Permit Inspections Harnett County

Permit Number: BRES2312-0208

Description: **total 12x30 additon =12x12 Sitting room 12x18 living room**

Site Address: **18 PINERIDGE CV**

**CRAWLSPACE FOUNDATION**

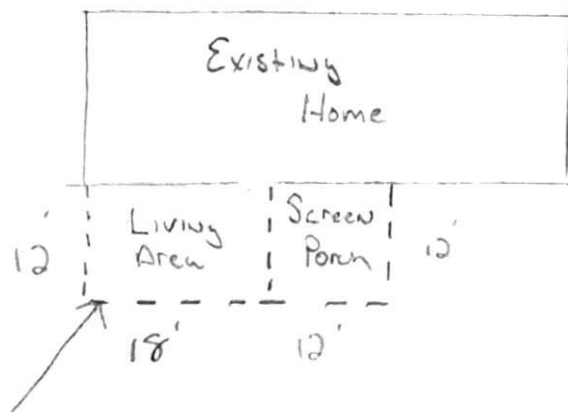
SEQ ID	SCHEDULED DATE	COMPLETED DATE	TYPE	INSPECTOR	RESULT	REMARKS
			FOUNDATION	James T Hall		
Notes:						
			MONO SLAB	James T Hall		
Notes:						
			OPEN FLOOR	James T Hall		
Notes:						
			UNDER SLAB TRADES	James T Hall		
Notes:						
			FINAL**	James T Hall		
Notes:						
	1/31/2024	1/31/2024	FOOTING	Steven Gazlay	DISAPPROVED	
Notes: No answer at door. Inspectors will not go into fenced backyards. Have approved plans onsite with Gate open. Must have 2 #4 rebar dowels into existing footings at each tie in. Need pour depth markers. Washed in soils must be removed. Sewer will need to be sleeved. Unable to complete inspection.						
	2/7/2024	2/7/2024	FOOTING	John B Kokoszka	APPROVED	
Notes:						
	3/22/2024	3/22/2024	ROUGH IN	Steven Gazlay	DISAPPROVED	
Notes: Rough in inspections not completed. Foundation never inspected, provide third party appendix G inspection form. Have approved plan reviewed plans onsite.

( 10" opening Detail )

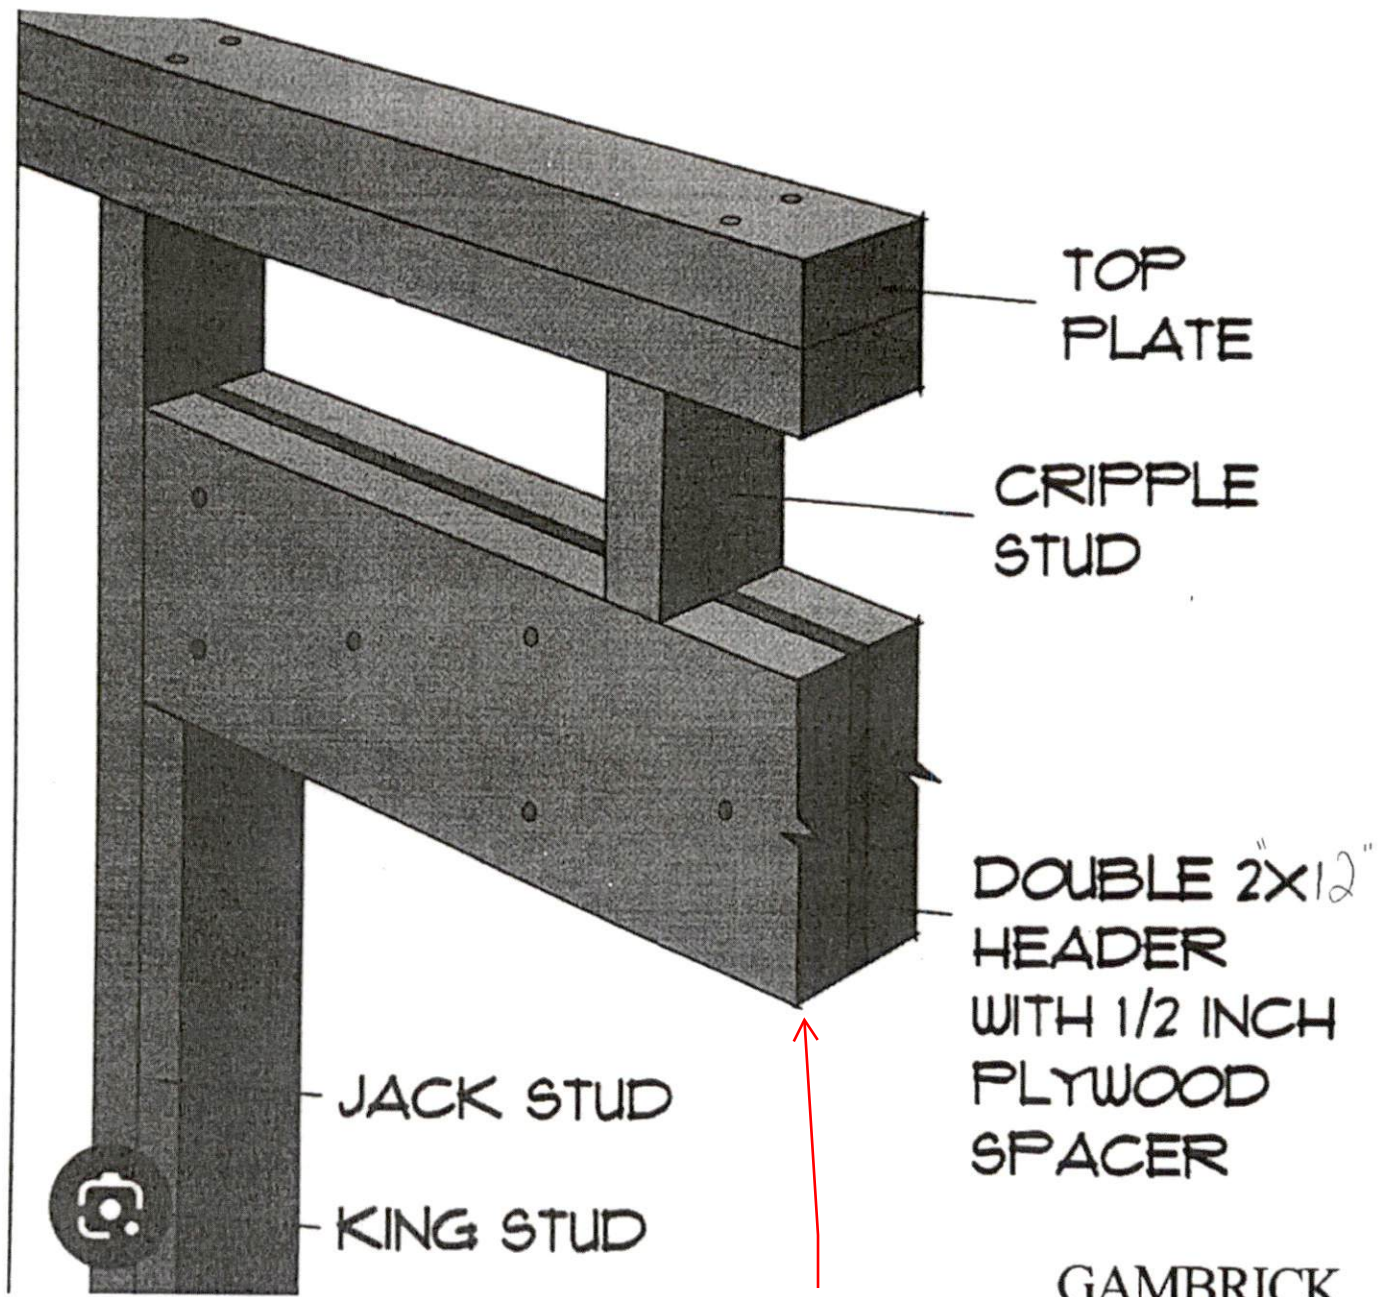
4/19/2024	4/19/2024	ROUGH IN REINSPECT	Scott Guy	DISAPPROVED	
<p>Notes:</p> <p>1/ all window rating decals have been removed 2/ missing LVL at 10' opening. 3/ roof slope min 3 - 12 verity required underlayment. 4/ need header over existing crawl opening. Ok to insulate</p> <p>1/ all window rating decals have been removed 2/ missing LVL at 10' opening. 3/ roof slope min 3 - 12 verity required underlayment. 4/ need header over existing crawl opening. Ok to insulate</p>						
	4/26/2024	4/26/2024	ROUGH IN REINSPECT	John B Kokoszka	APPROVED	
<p>Notes:</p> <p>Please call Harold Sanders when on the way at 910-610-1204</p> <p>Need to upload picture of the ice membrane</p>						
	4/29/2024	4/29/2024	INSULATION	James T Hall	APPROVED	
<p>Notes:</p>						
	5/23/2024	5/23/2024	FINAL**	Steven Gazlay	DISAPPROVED	
<p>Notes:</p> <p>No inspection. Foundation never passed inspection, need appendix G form.</p>
